**United Utilities Water Limited
Developer Services & Planning**
Warrington North WWTW
Barnard Street off Old Liverpool Road
Gatewarth Industrial Estate
Sankey Bridges
Warrington
WA5 1DS

Your ref: 3/2016/0069
Our ref: DC/16/682
Date: 07-MAR-16

Location: 7 Accrington Rd, Whalley

Proposal: demolition of former nursery & erection of new retail & office building with car parking

Site Plan
Scale: 1:500

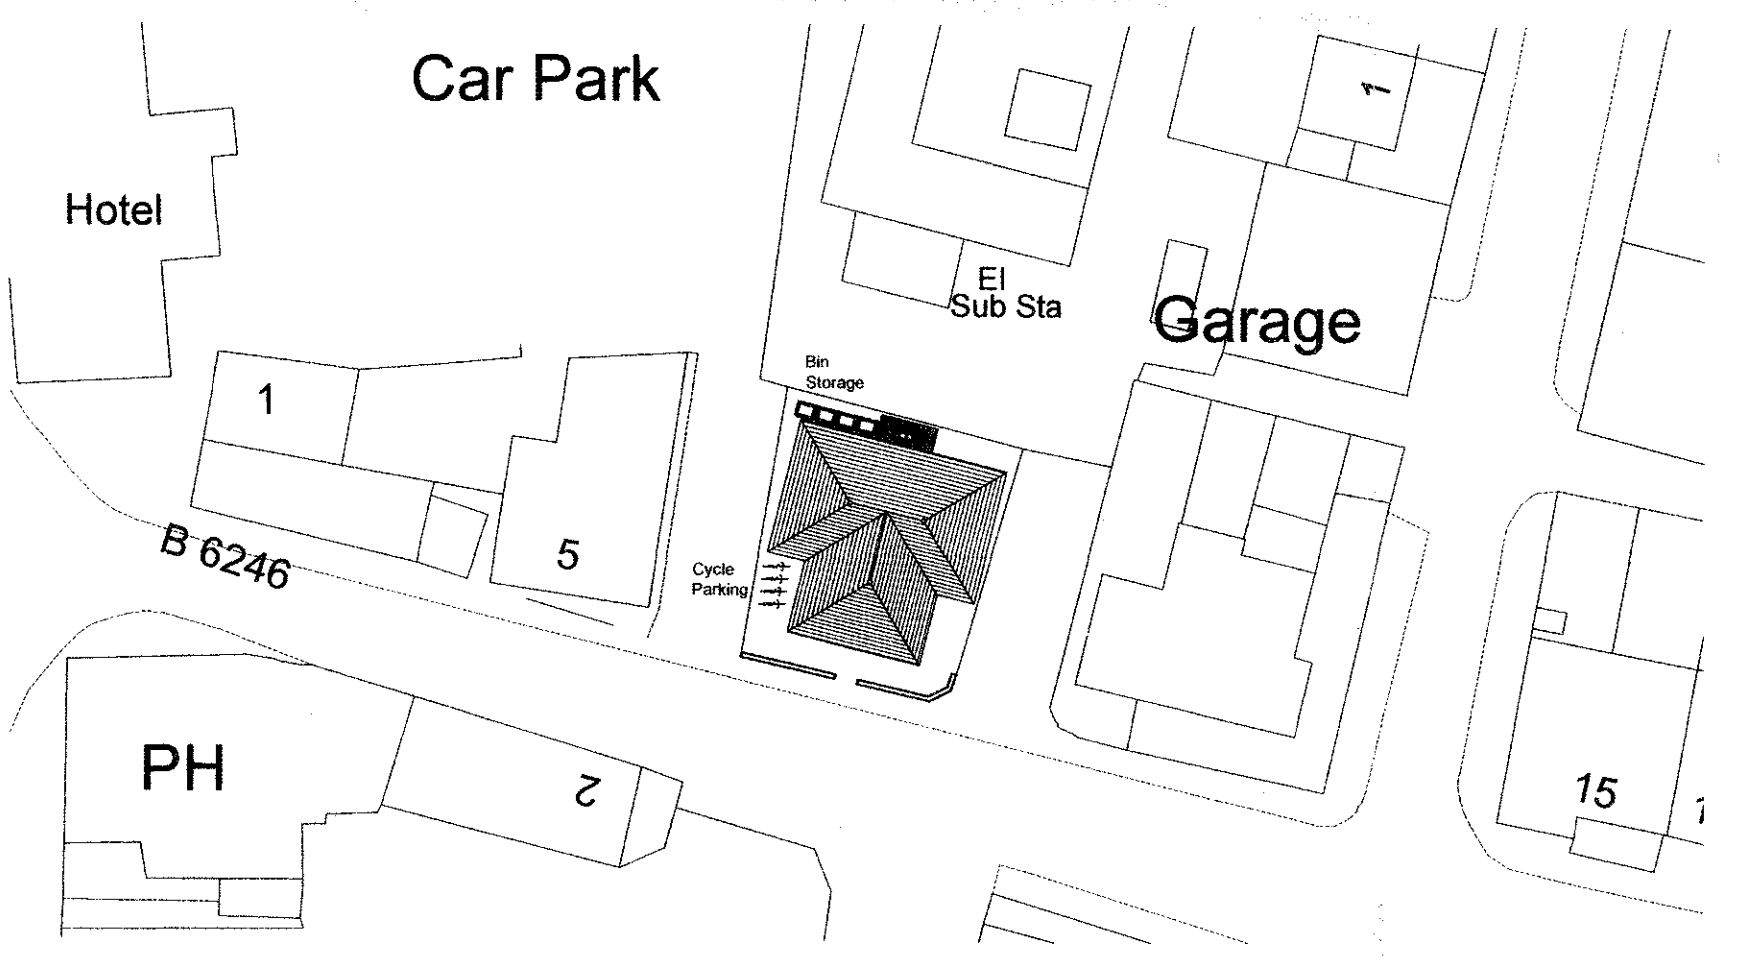
A public sewer crosses this site and we may not permit building over it. We will require an access strip width of six metres, three metres either side of the centre line of the sewer which is in accordance with the minimum distances specified in the current issue of "Sewers for Adoption", for maintenance or replacement. Deep rooted shrubs and trees shall not be planted within the canopy width (at mature height) of the public sewer and overflow systems. Trees should not be planted directly over sewers or where excavation onto the sewer would require removal of the tree.

A water main is located adjacent at the southern boundary of the development. As we need access for operating and maintaining it, we will not permit development in close proximity to the main. You will need an access strip of no less than 5 metres, measuring at least 2.5 metres either side of the centre line of the pipe. The applicant must comply with our standard conditions, a copy of which is enclosed, for work carried out on, or when crossing aqueducts and easements. This should be taken into account in the final site layout, or a diversion will be necessary, which will be at the applicant's expense. Any necessary disconnection or diversion required as a result of any development will be carried out at the developer's expense. Under the Water Industry Act 1991, Sections 158 & 159, we have the right to inspect, maintain, adjust, repair or alter our mains. This includes carrying out any works incidental to any of those purposes

According to our records there is an easement (060/00367E) protecting a main water pipe that runs adjacent to the boundary line at the front of the proposed development site. Under no circumstances should anything be erected, planted or stored over the easement width, nor should anything occur that may affect the integrity of the pipe or United Utilities legal right to 24hr access.
